Your Ref: Inet 000002926
Our Ref: P/146/07/
Please ask for:
Mrs A Gardner

14th December 2007

Demolition of existng two bed bungalow and erection of two bed bungalow and garage
129 East Front Road Pagham

PLAN NO 621/1
SCALES 1:100 1:200 1:50
DATE 11/06

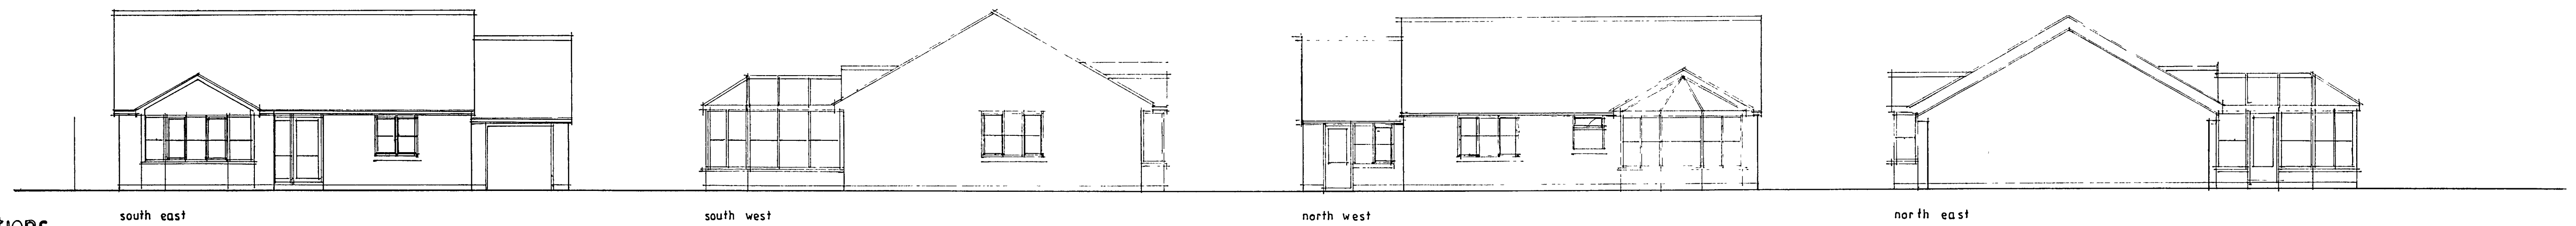
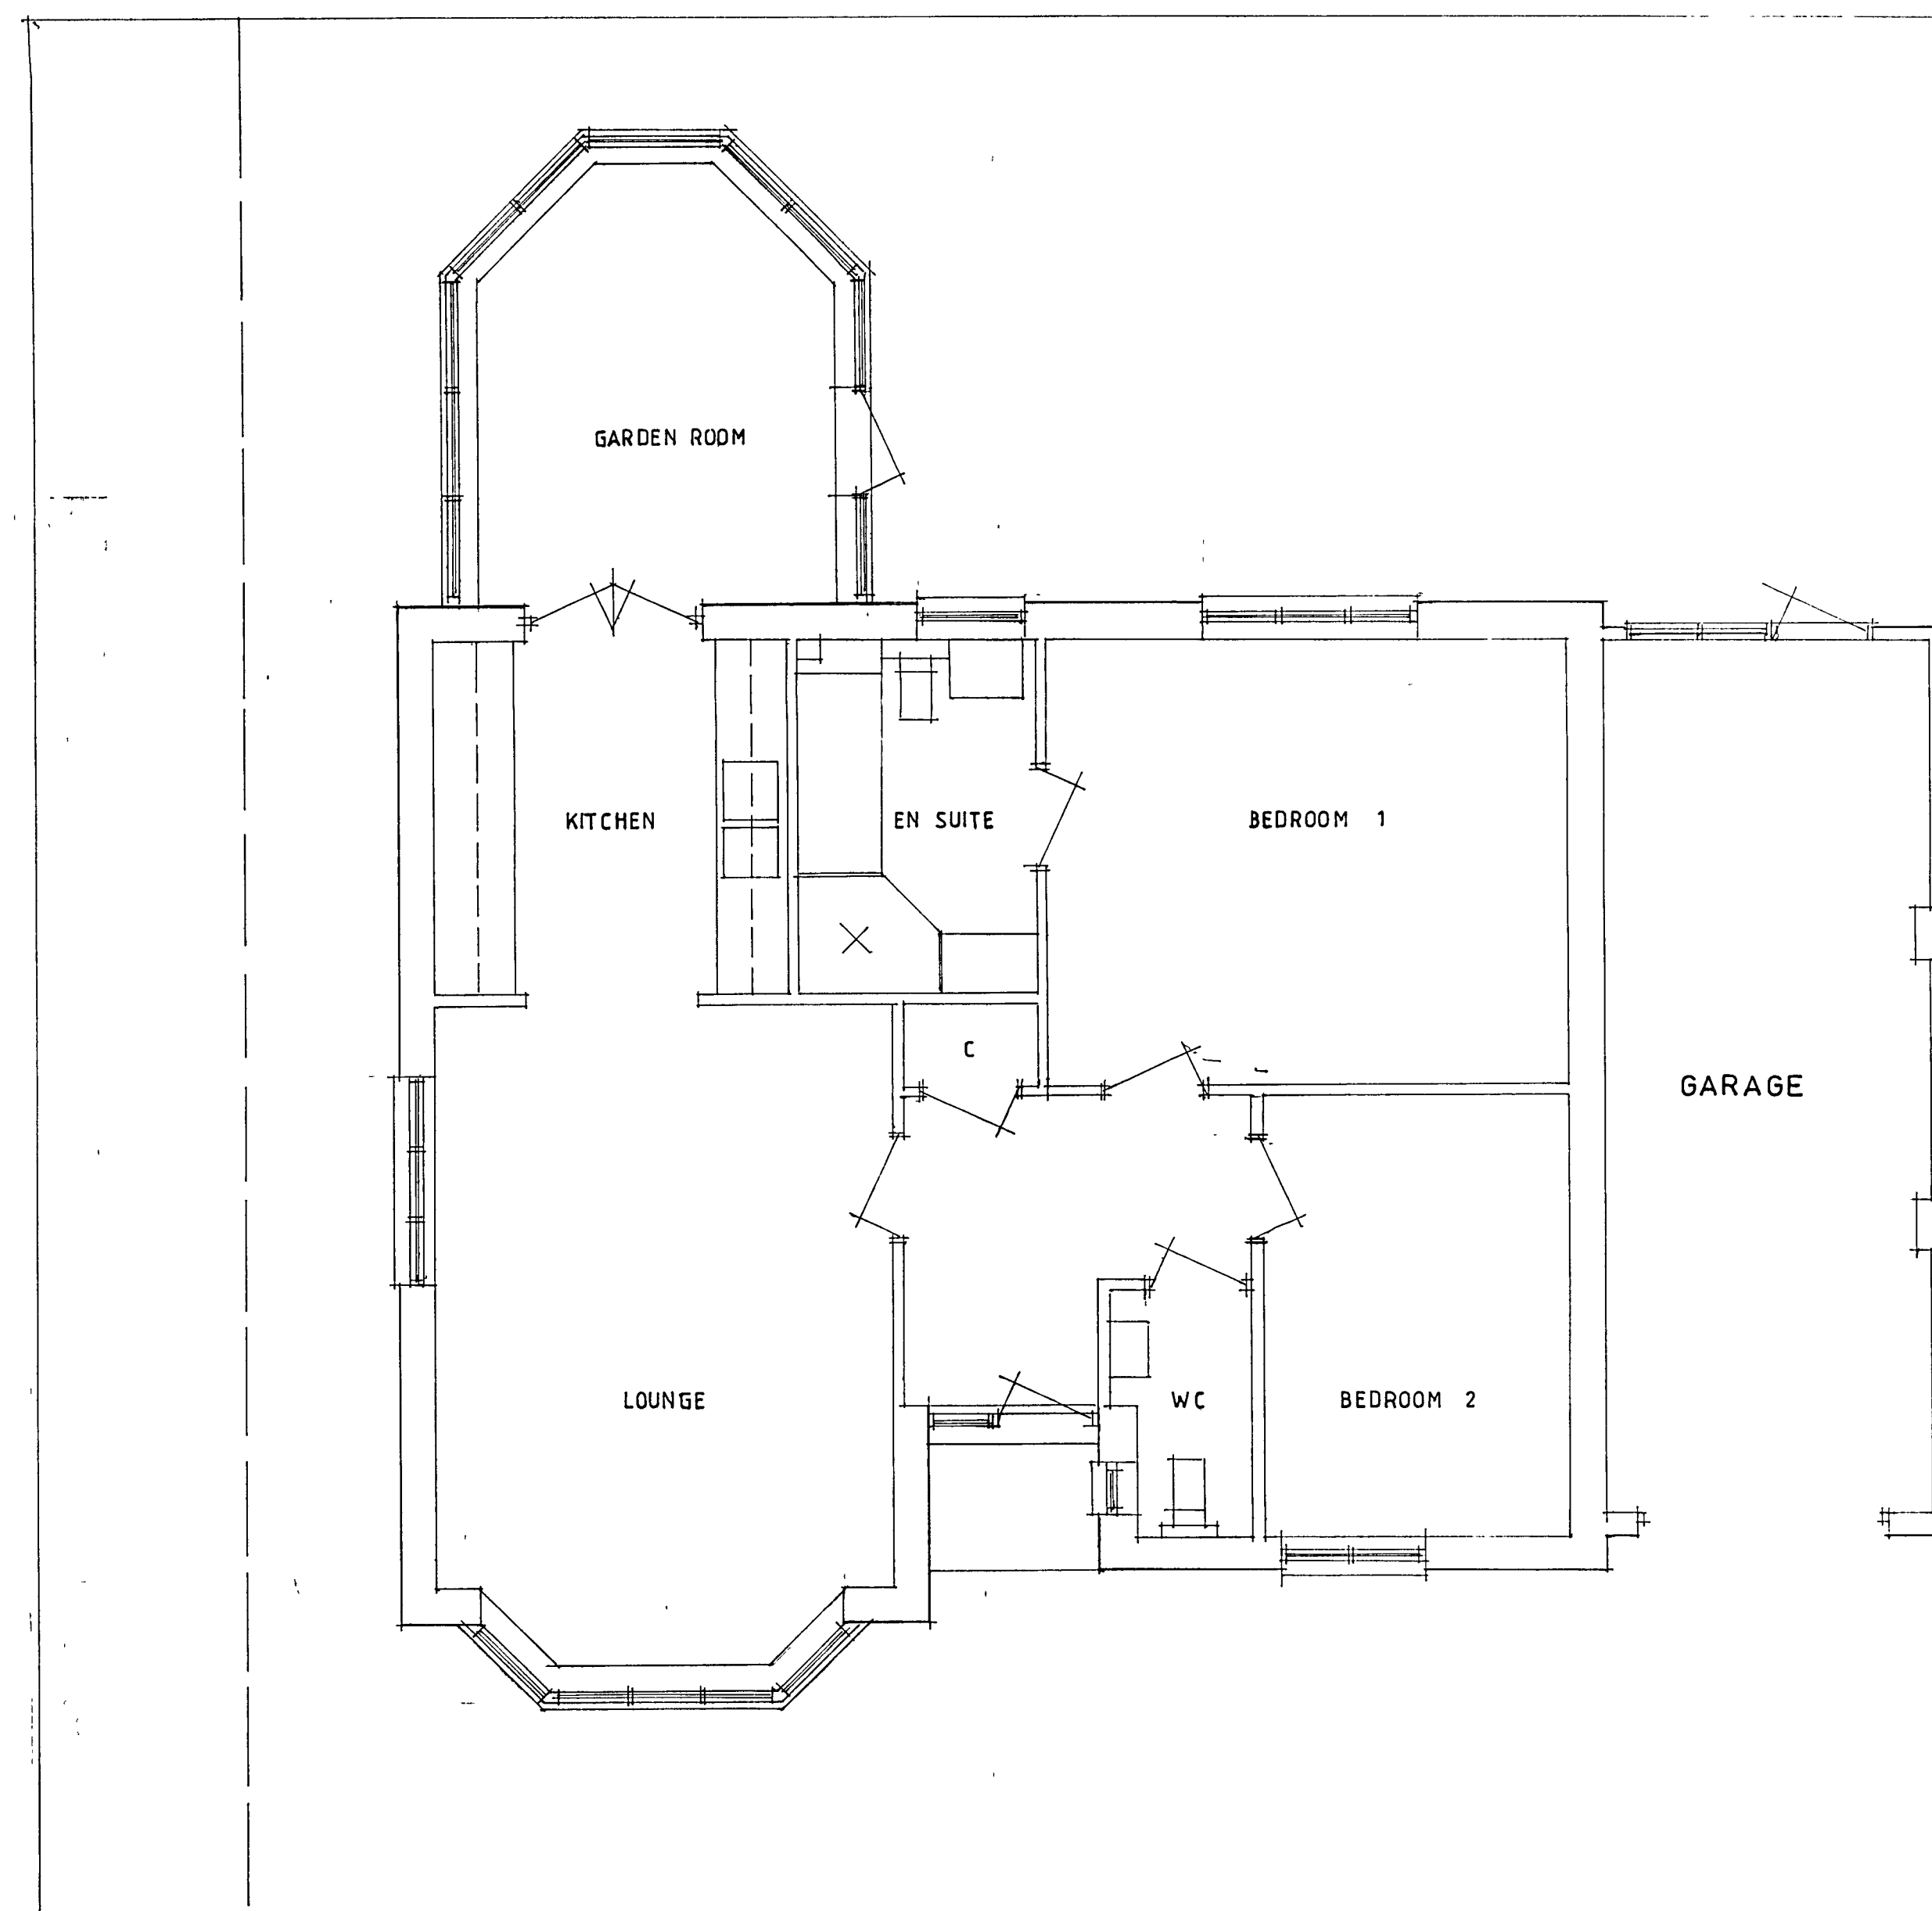
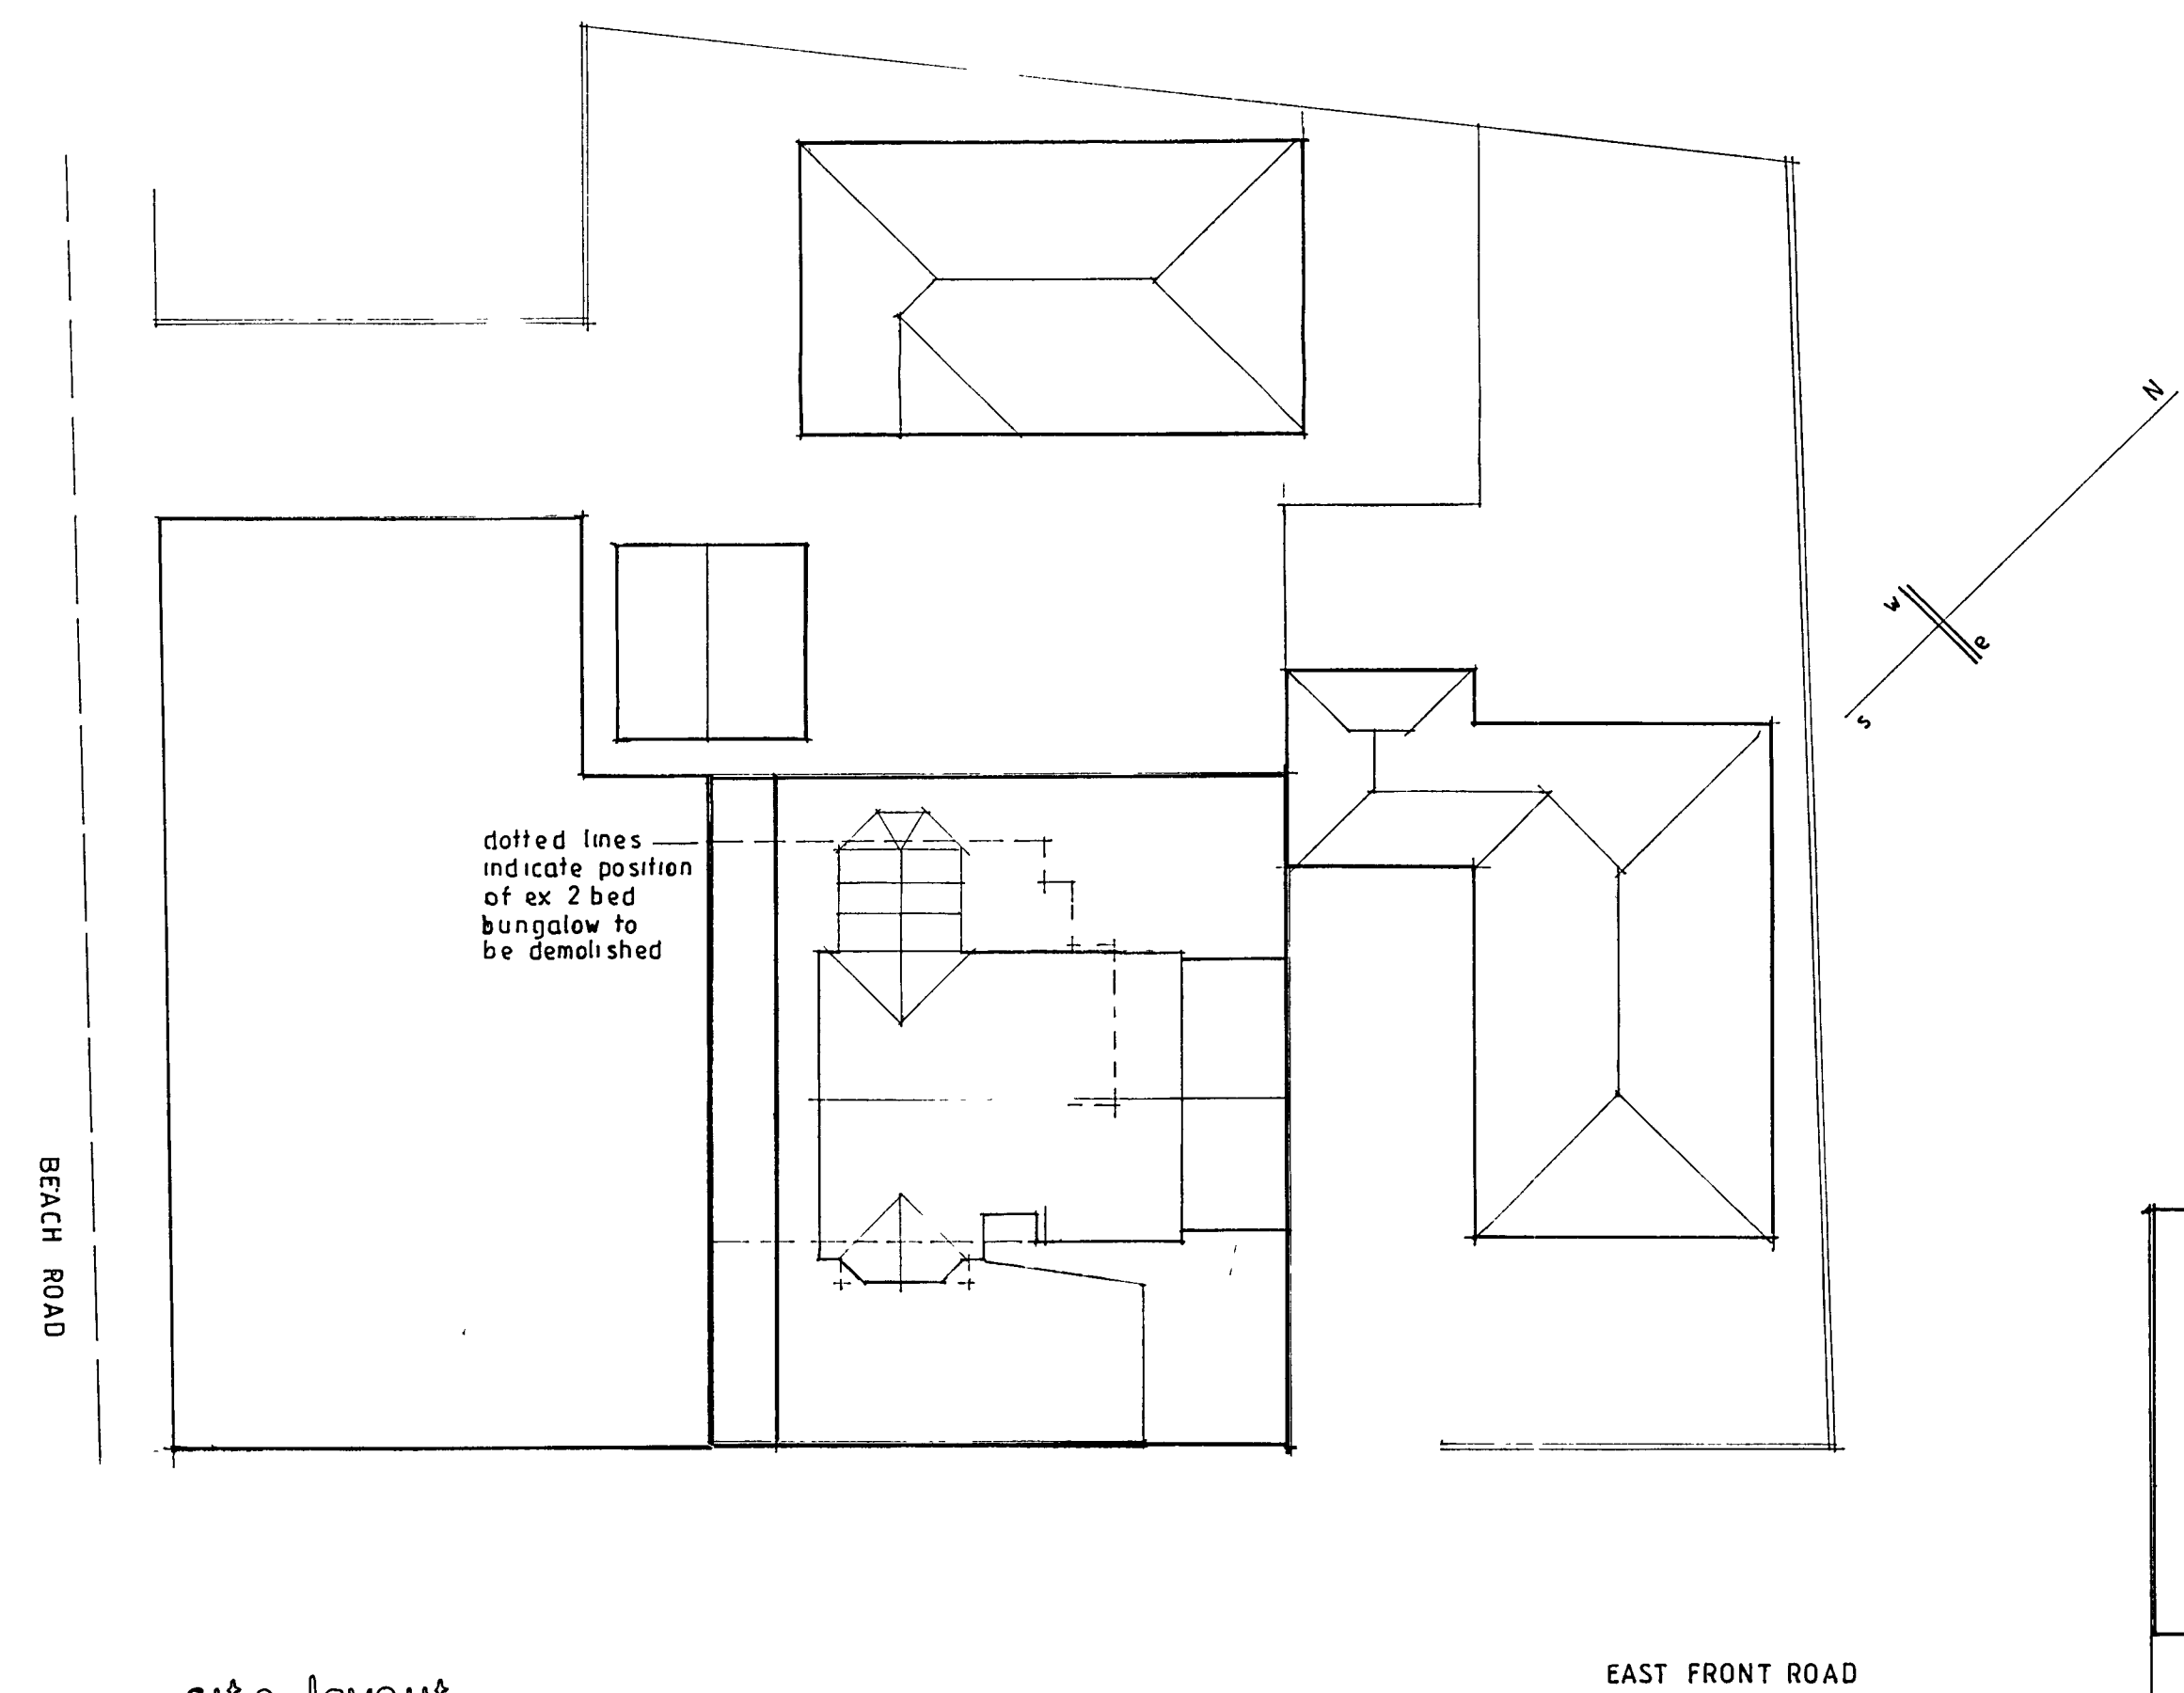
The requirement for raising the finished floor levels is acknowledged in the Design and Access Statement, where mention is made of the finished floor levels of the newly erected adjoining buildings. However given that the minimum floor levels are under continuous review, the EA needs be consulted in this respect.
